DEVIATION REQUEST (Attach diagrams, figures, and other documentation to clarify request)

A deviation from the standards of or in **Table 2-4** of the Engineering Criteria Manual (ECM) is requested.

- **Table 2-4 Roadway Design Standards for Rural Minor Arterials specifies lane width of 12 feet and paved shoulder width of 8 feet.**

WINSOME FILING NO. 1
 EL PASO COUNTY, COLORADO
 CONSTRUCTION DOCUMENTS
ACCELERATION LANE PLAN

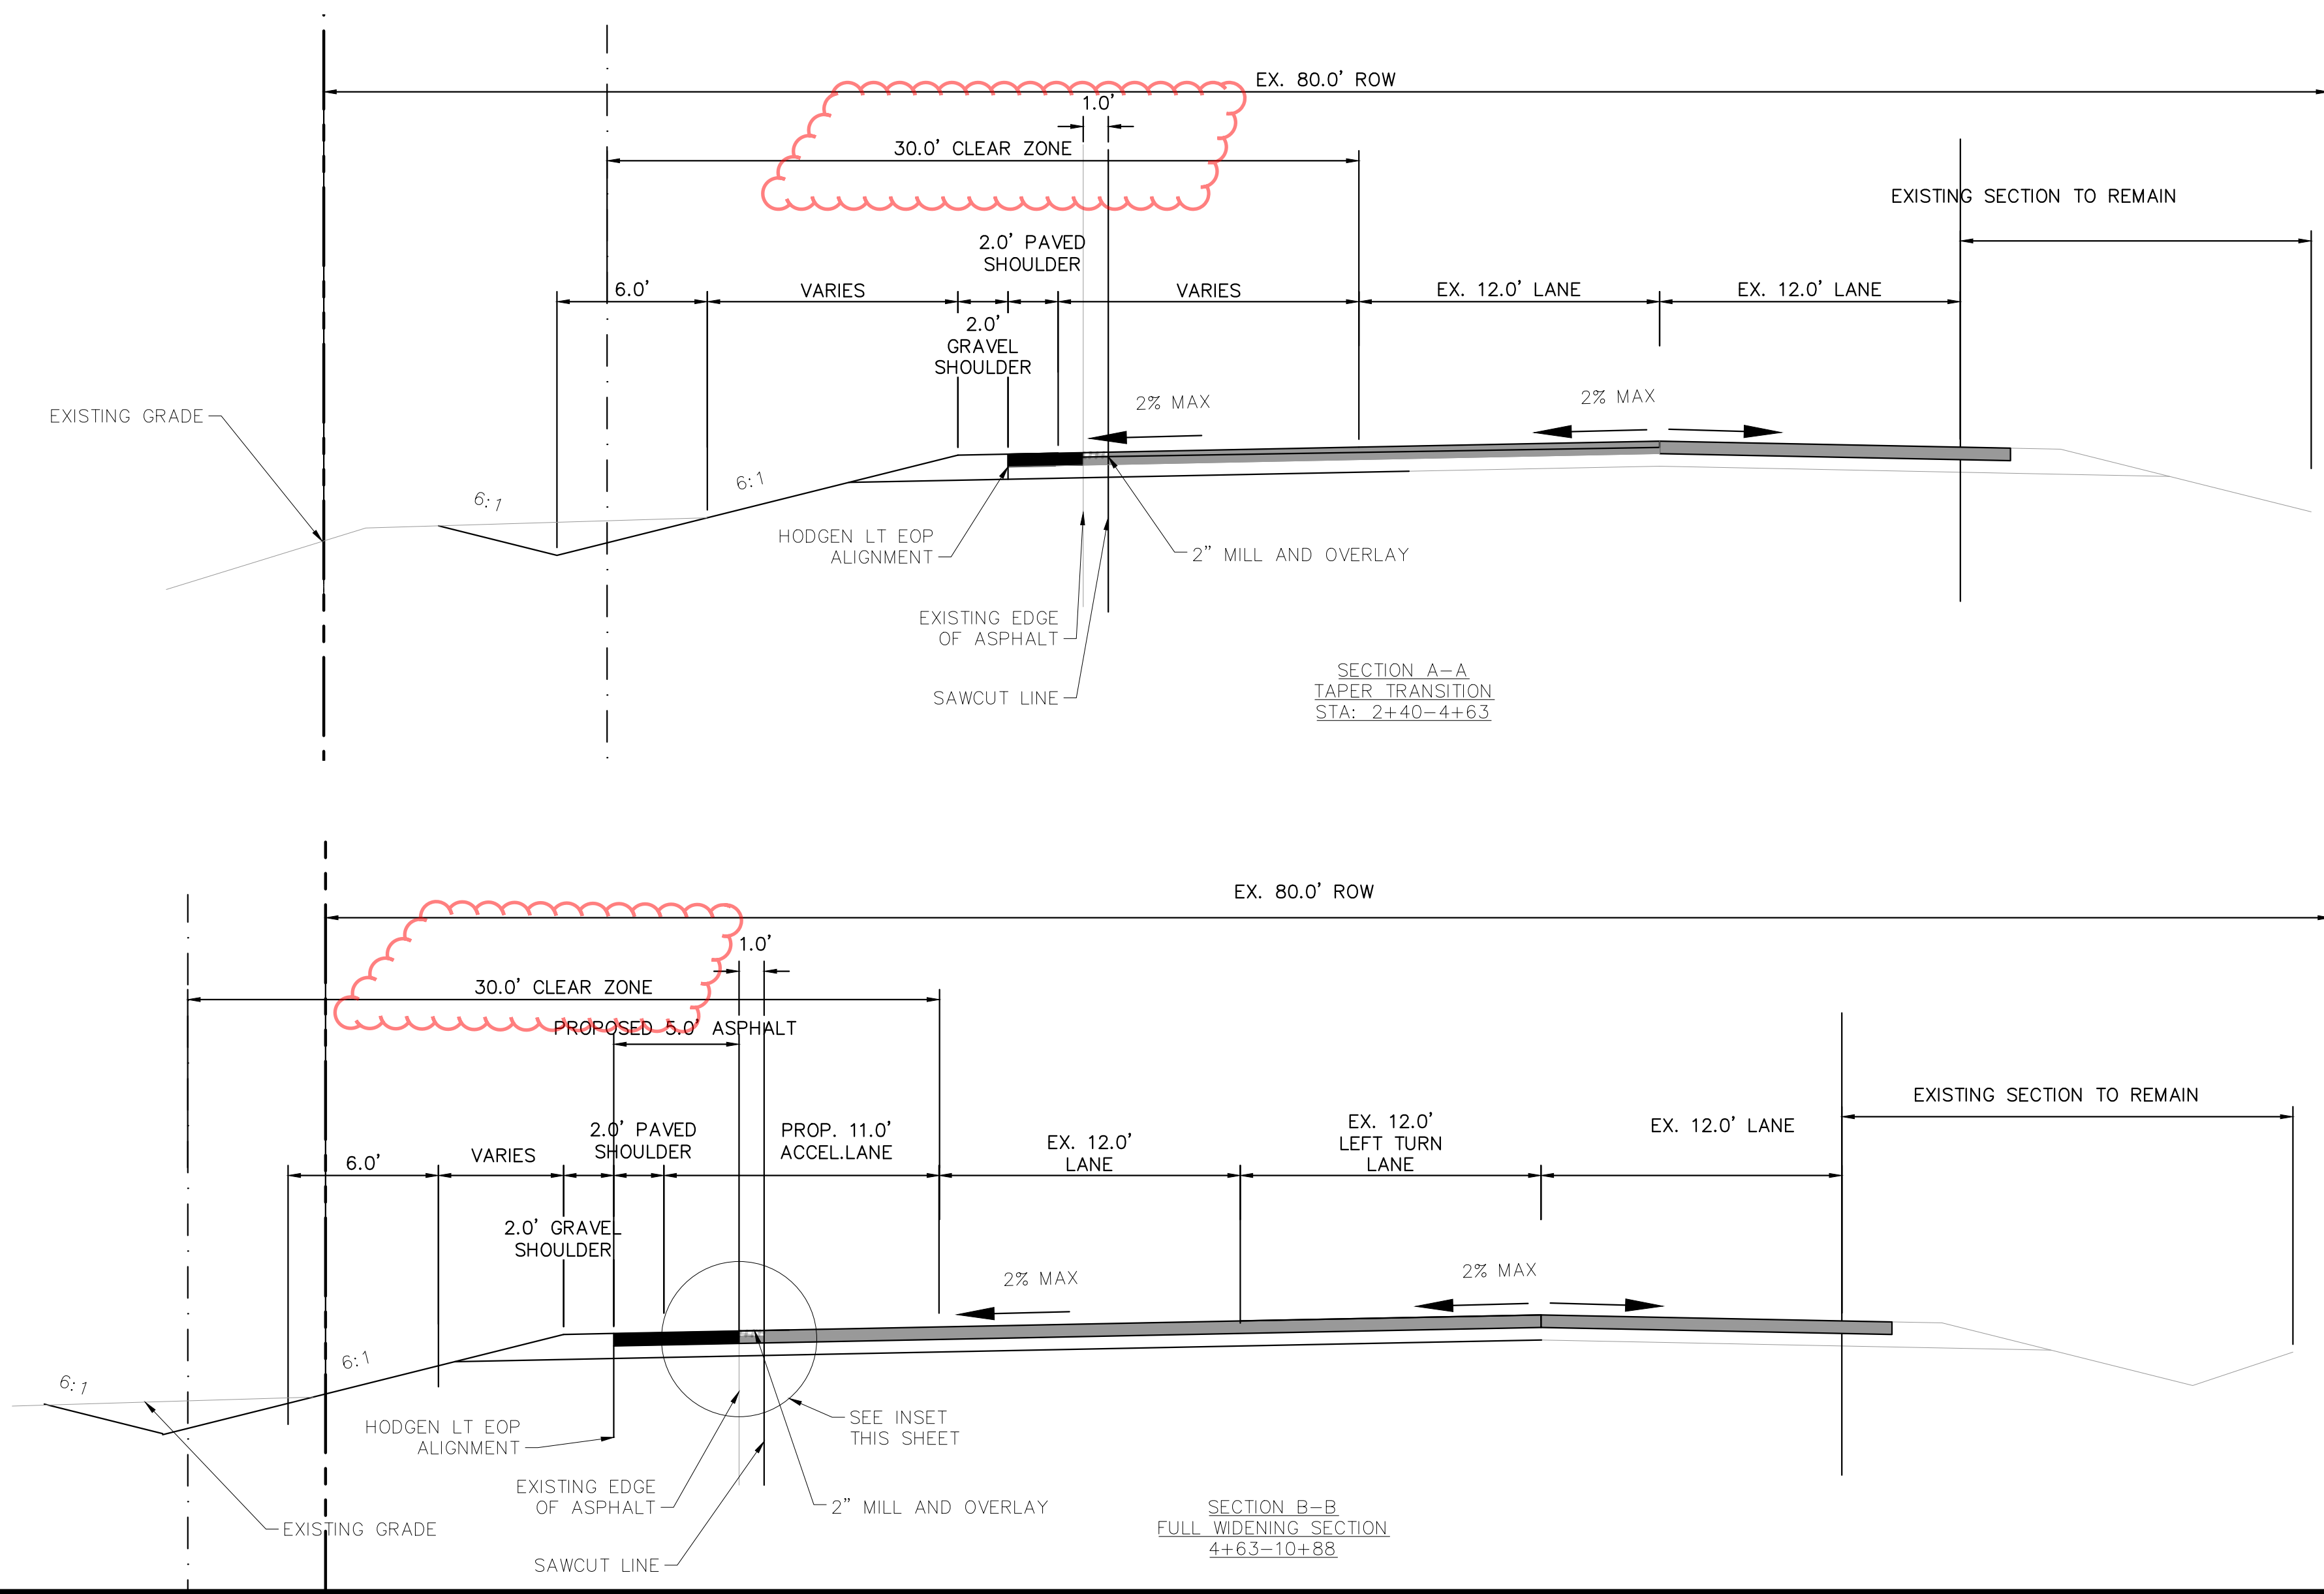
Delete this deviation request and incorporate into the Deviation Request for Stopping Sight Distance.

The turn lane is related to mitigating the the SSD deficiency in the interim.
